**From:** planning  
**Subject:** FW: Consultation on Planning Application 3/2016/0236 and 3/2016/0238 Meeting House Sawley Raod Grindleton BB7 4RS For attn Adrian Dowd

The application is for: Grade II Listed Quaker Meeting House , with an attached cottage for which approval is sought to combine into a single domestic dwelling. This will involve internal alterations to form new openings between the existing cottage Scullery and Meeting House Disabled WC, conversion of the existing Meeting House Kitchen into an Entrance Hall and Cloaks Cupboard and the opening up of the wall between the existing Kitchen and Sitting Room of the Cottage to form a large Kitchen/Dining Area.

Existing Plans

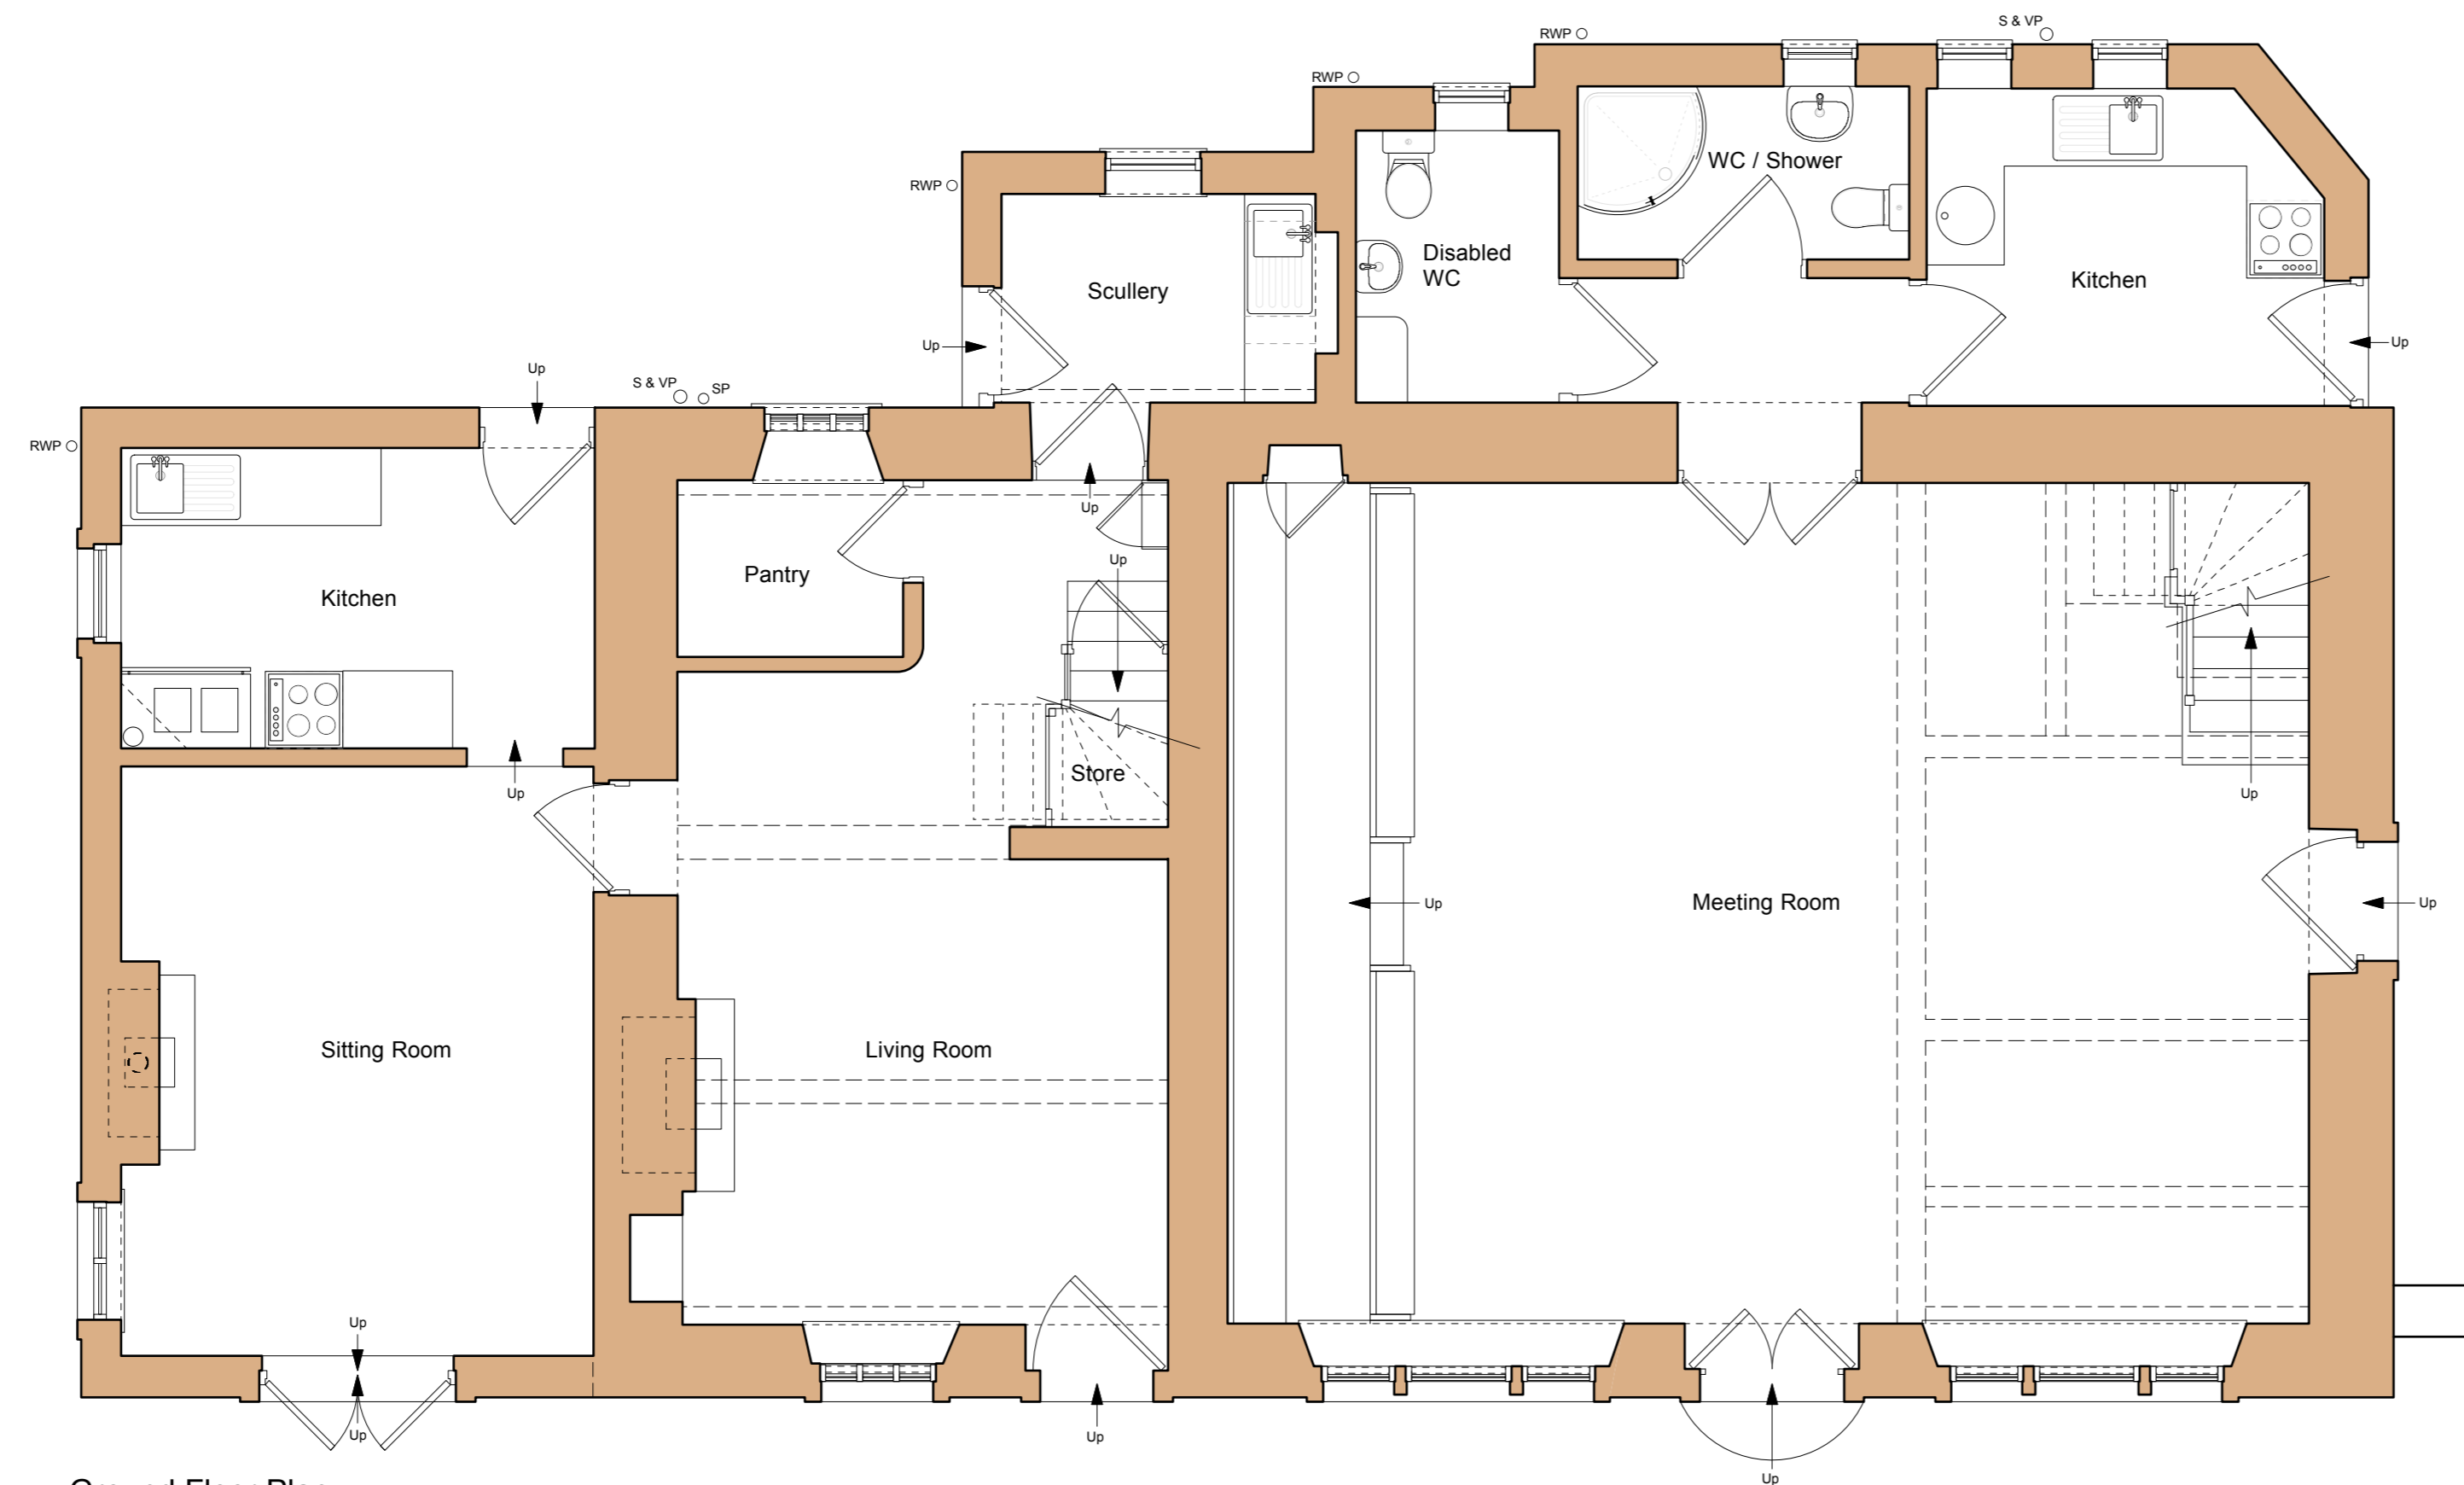
Comparison between the Existing and Proposal drawings implies that no alterations at all are in prospect for the interior of the Meeting House itself. This is of course welcome but is that really the case ? Is the seating which is very important to the simple but evocative character to be wholly retained ? . It is important too that the enclosed nature of the gallery ( with its flap ) is preserved as this is pivotal to the gender differentiation which is so fundamental to the historic character.

Proposed Plans

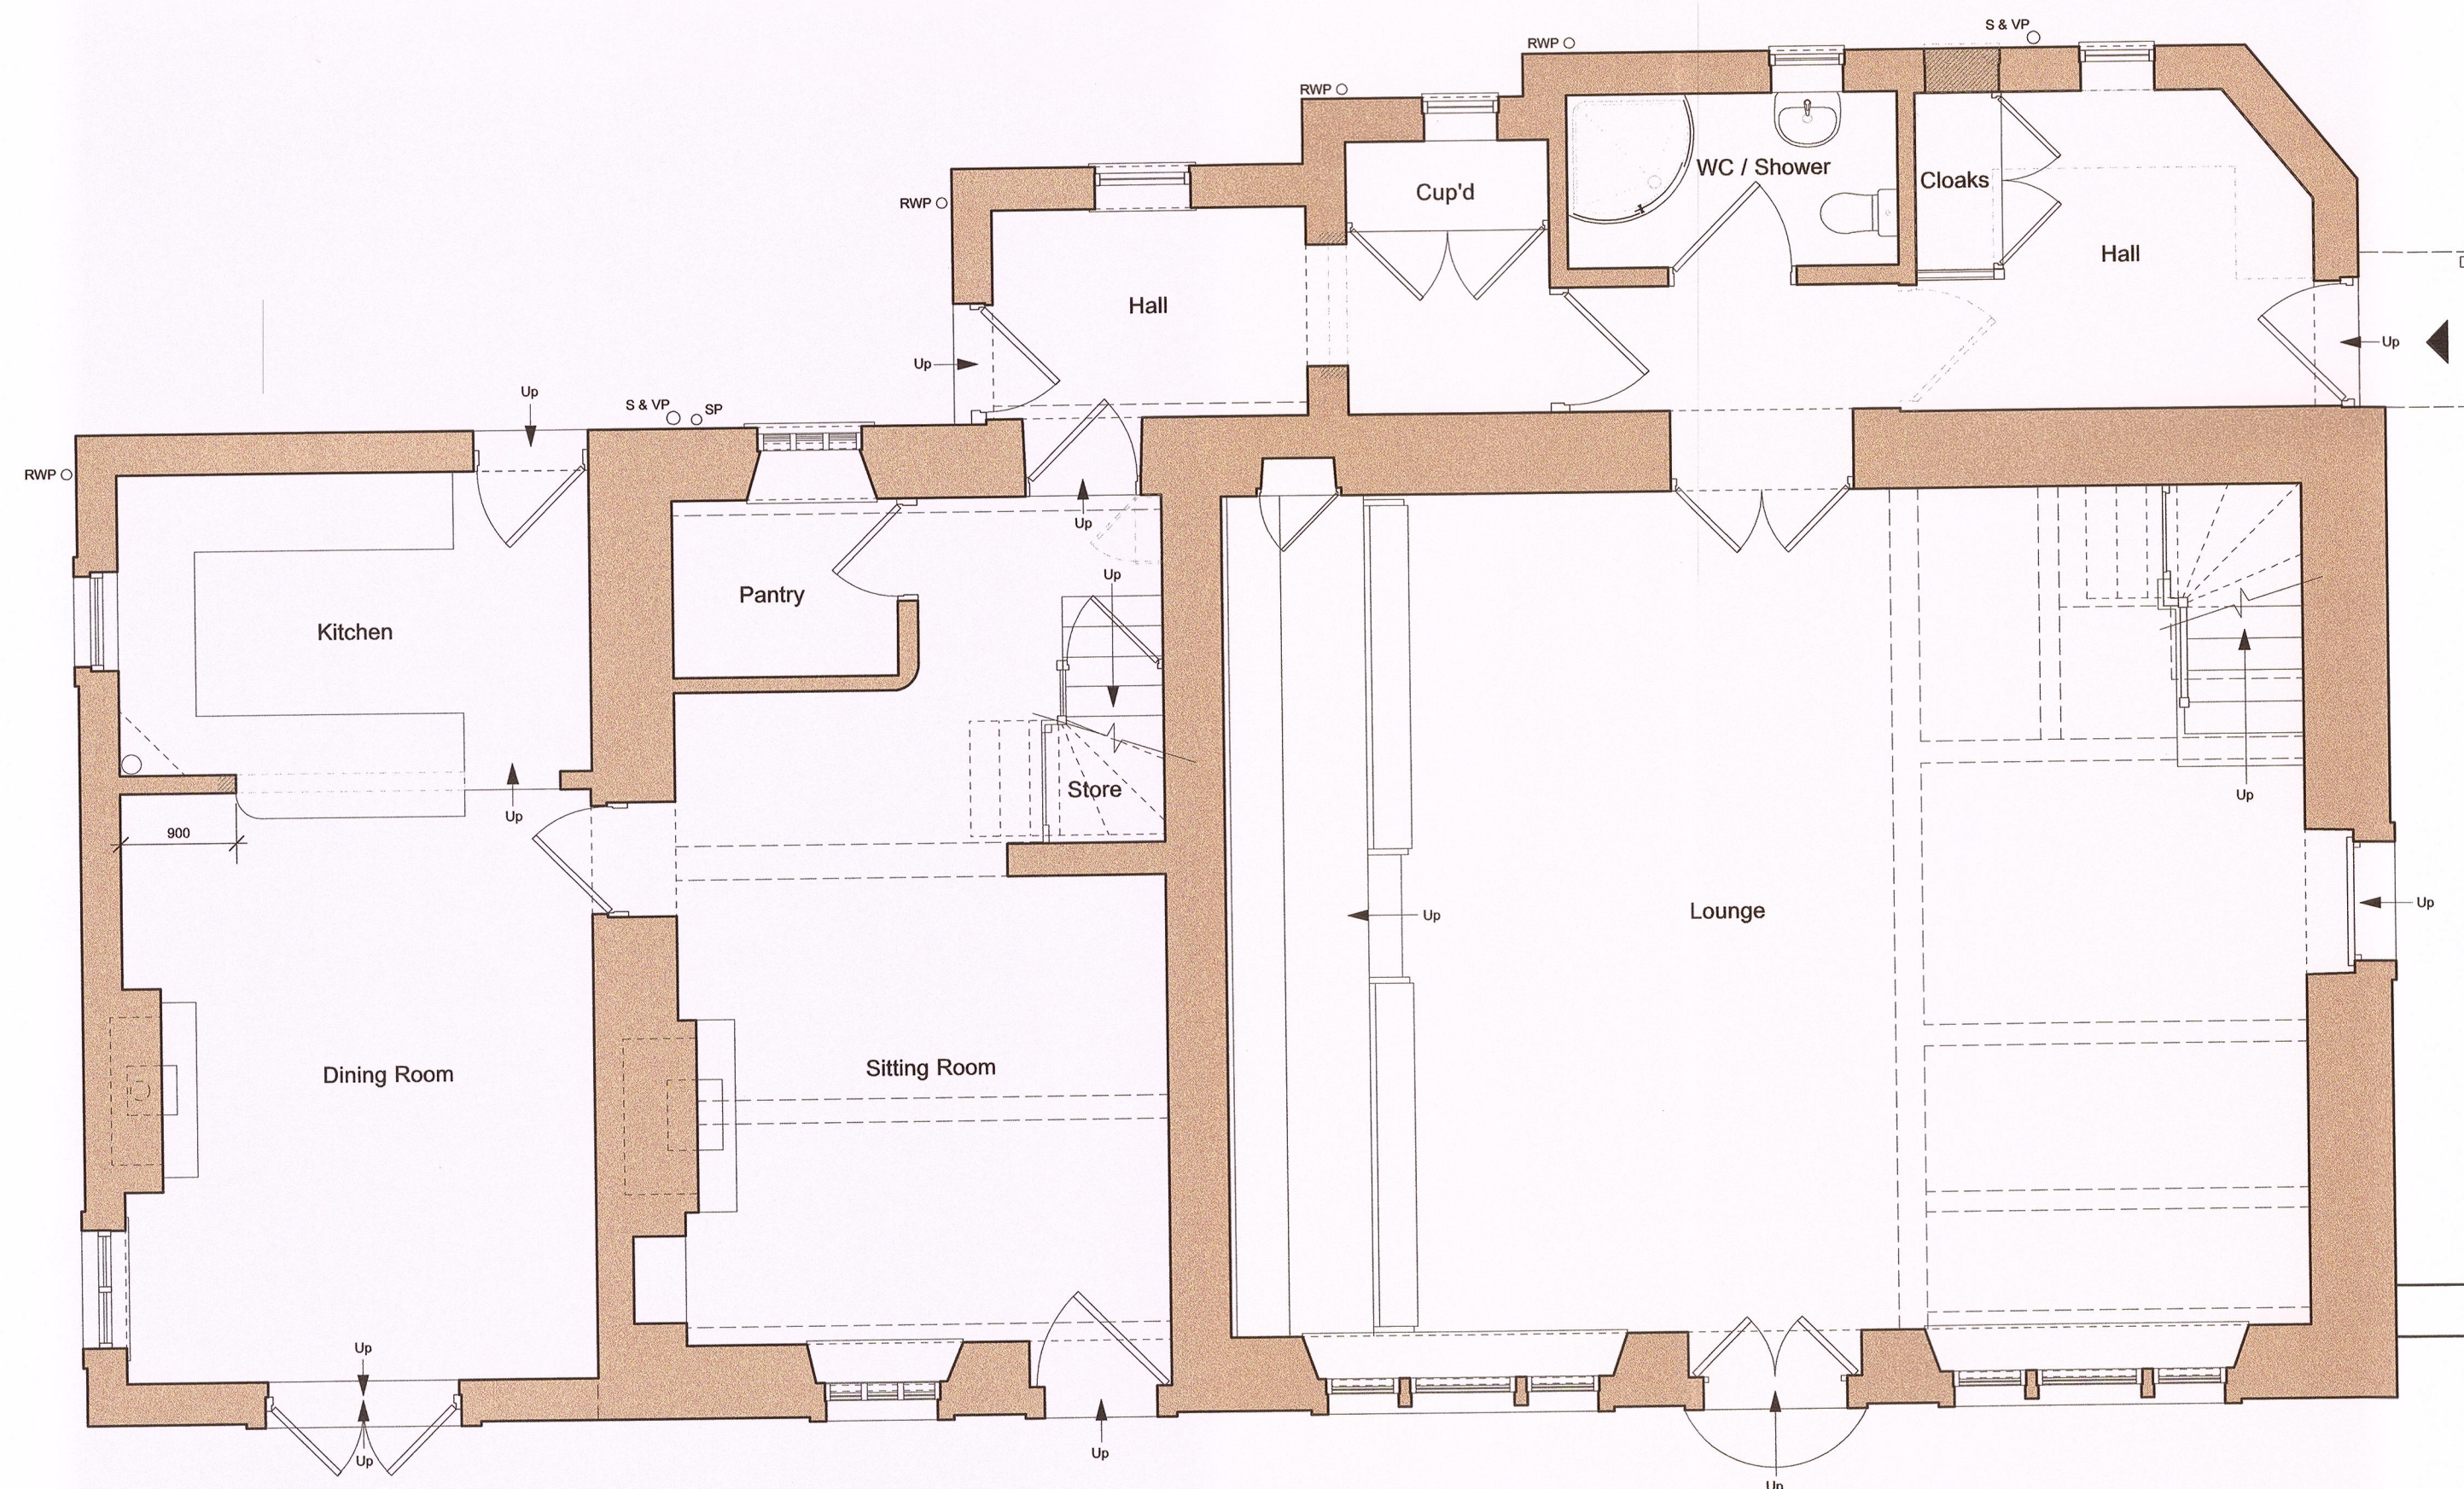
There are no plans as proposed of the whole site – will there be any changes to the historic setting ?
